**City of Portland, Maine - Building or Use Permit Application**

<b>Permit No:</b> 10-0410	<b>Issue Date:</b>	<b>CBL:</b> 087 II010001
------------------------------	--------------------	-----------------------------

<b>Past Use:</b> Single Family Home	<b>Proposed Use:</b> Single Family Home - Kitchen & Bath Remodel & permit existing 11' x 12' deck	<b>Permit Fee:</b> \$100.00	<b>Cost of Work:</b> \$8,000.00	<b>CEO District:</b> 1
<b>Proposed Project Description:</b> Kitchen & Bath Remodel & permit existing 11' x 12' deck		<b>FIRE DEPT:</b> <input type="checkbox"/> Approved <input type="checkbox"/> Denied	<b>INSPECTION:</b> Use Group: Type:	
		Signature:	Signature:	
<b>PEDESTRIAN ACTIVITIES DISTRICT (P.A.D.)</b>				
Action: <input type="checkbox"/> Approved <input type="checkbox"/> Approved w/Conditions <input type="checkbox"/> Denied				
		Signature:	Date:

Existing Deck Framing

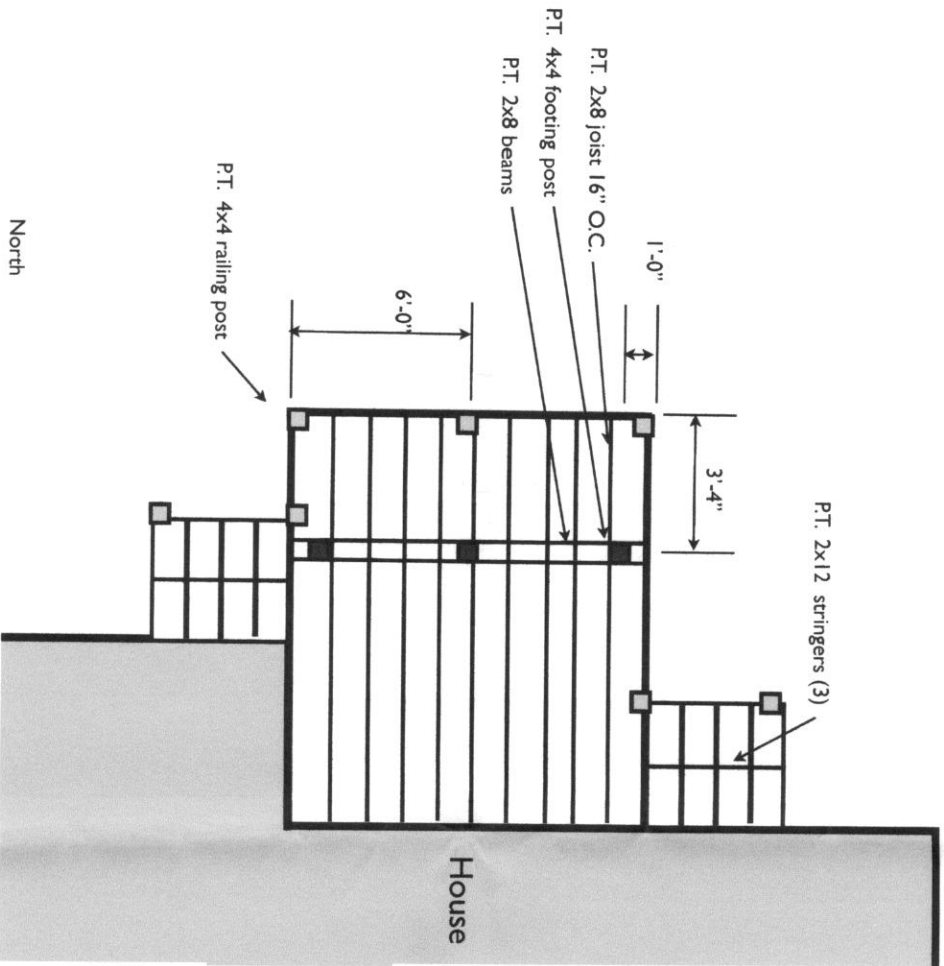
5/12/2010-jmb: Spoke with the Machlin's, confirmed deck information they think it's probably over 10 years old, the cantilever is a bit over the code recommended 34", but it looks like all other life safety codes are ok. They may enclose it at some point, will apply for permit additional supports will be required.
